# Charlotte Department of Transportation Memorandum

**Subject:** Rezoning Petition 05-140: Located west of North Wendover Road and  
northeast of Wendwood Lane  
(Revised 12/14/05)

TECHNICAL DATA SHEET

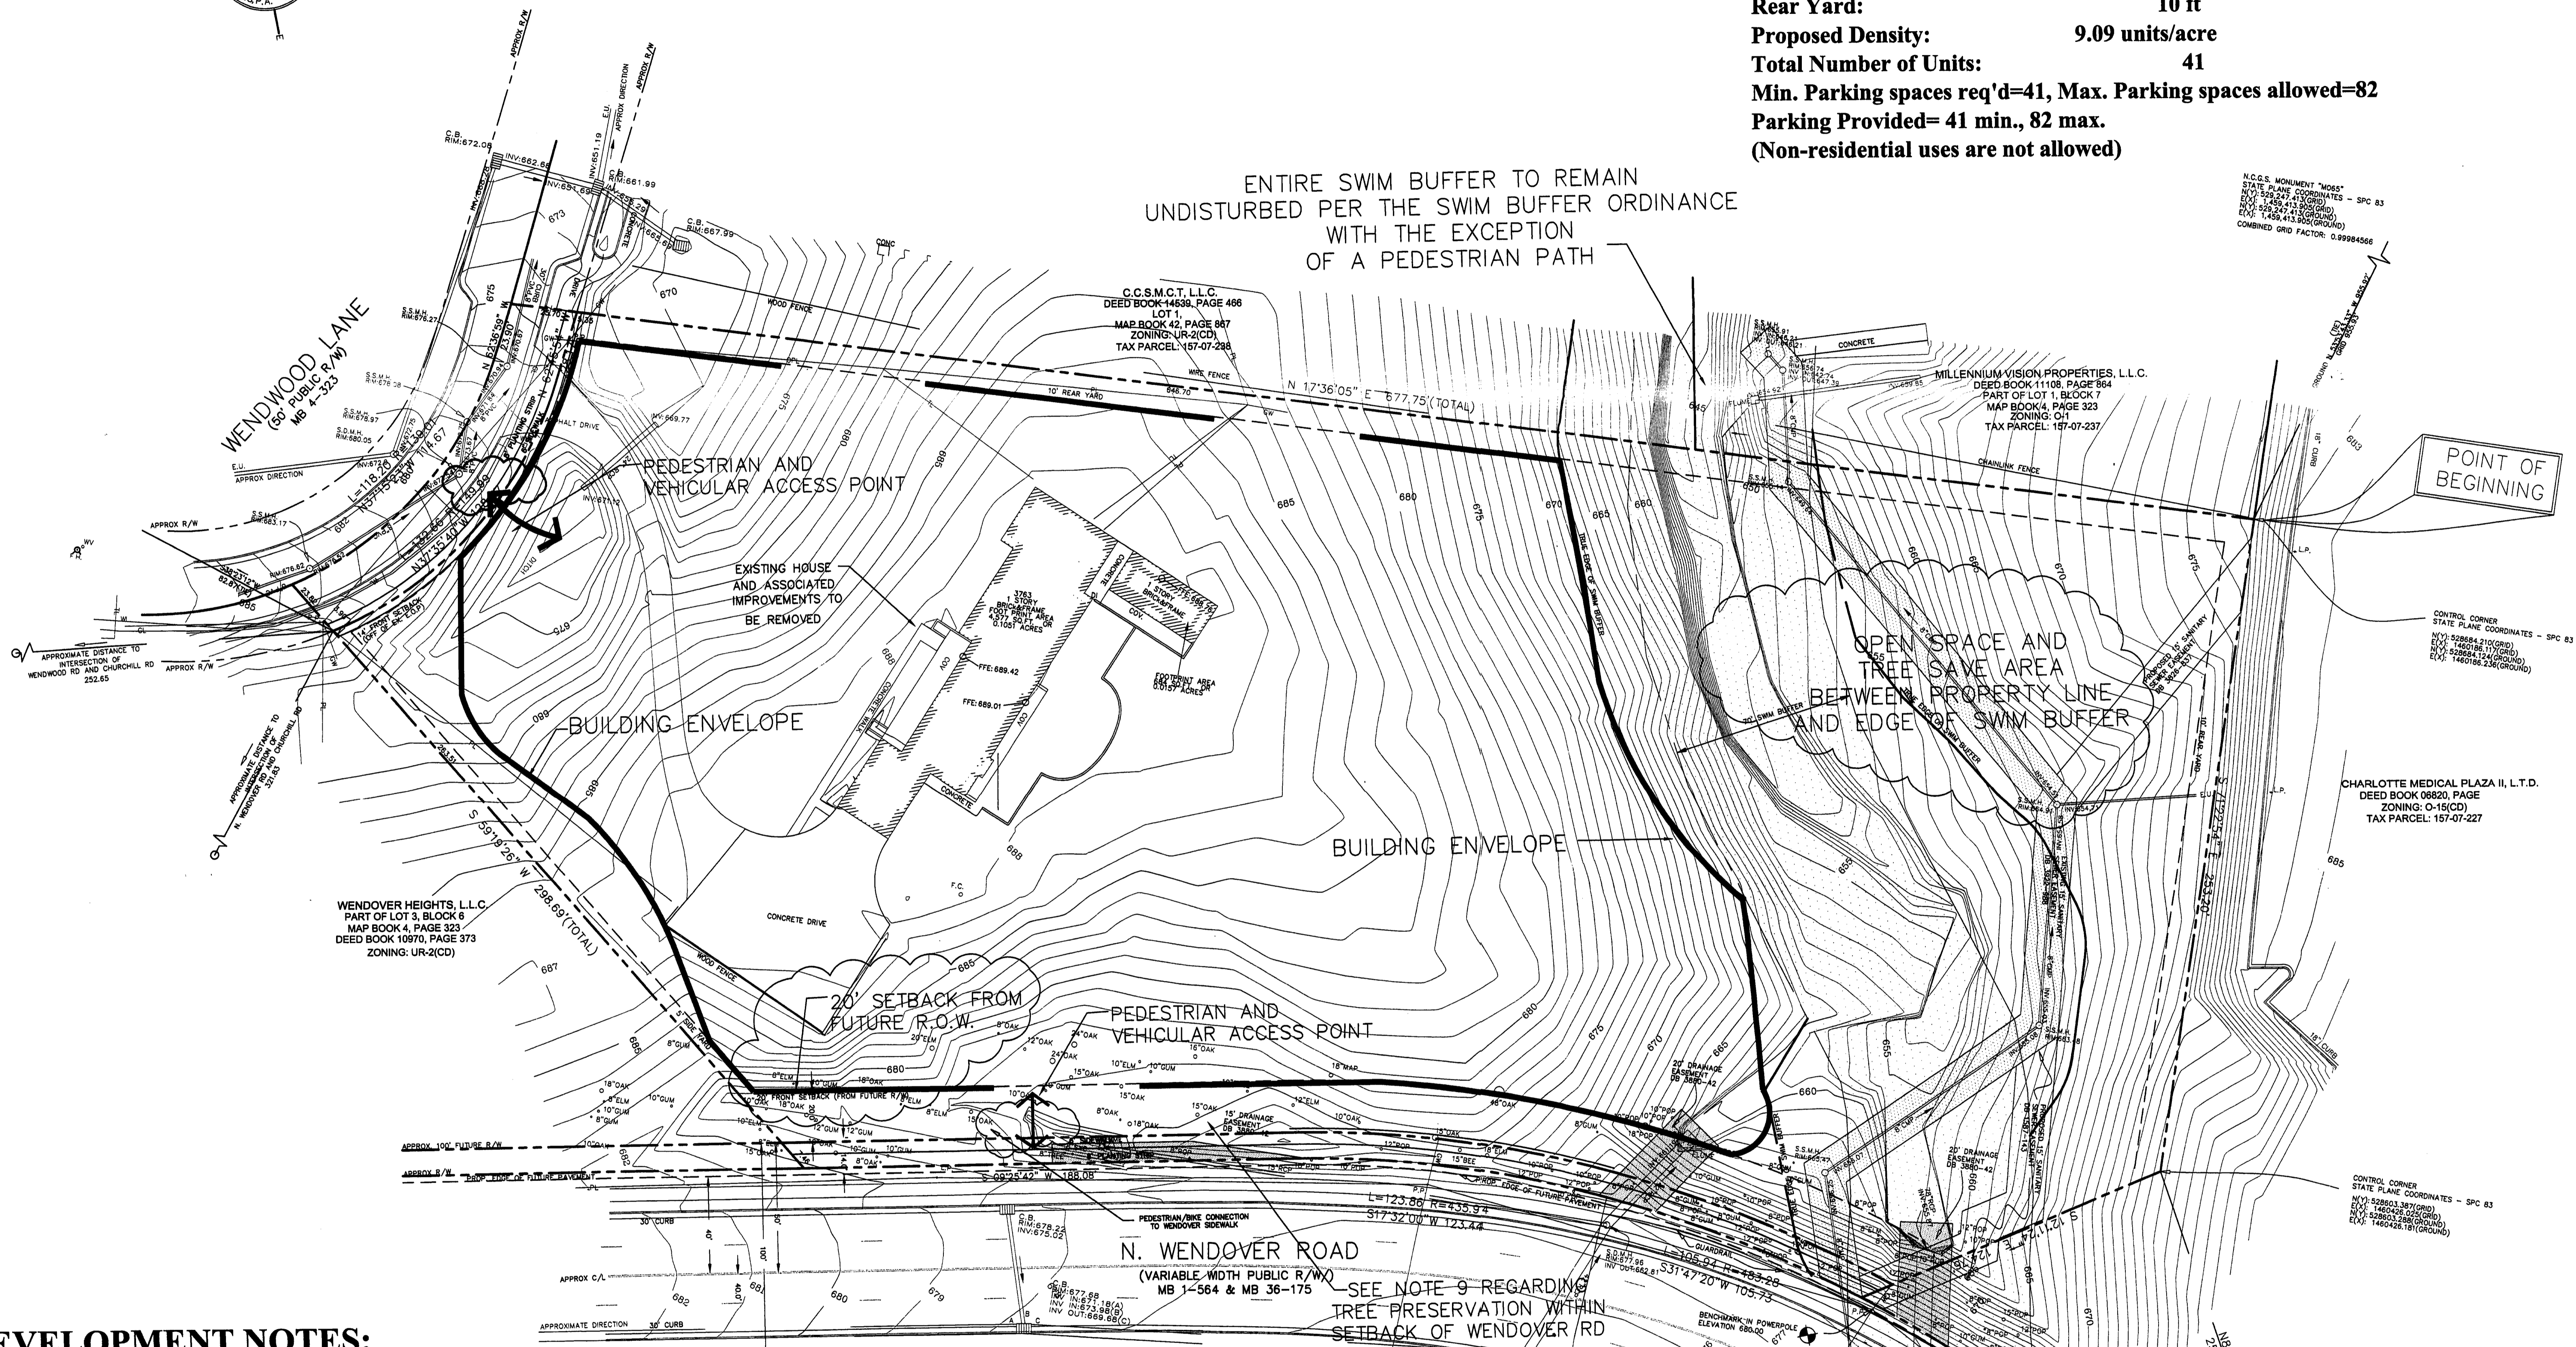
In the UR-2 zoning district, setbacks are measured from the back of an existing or proposed curb line. The future curblines for Wendover Road, as determined by CDOT and CMPC, is 72 feet back-of-curb to back-of-curb, or 36 feet from the existing centerline of the roadway to the back-of-curb along this site.
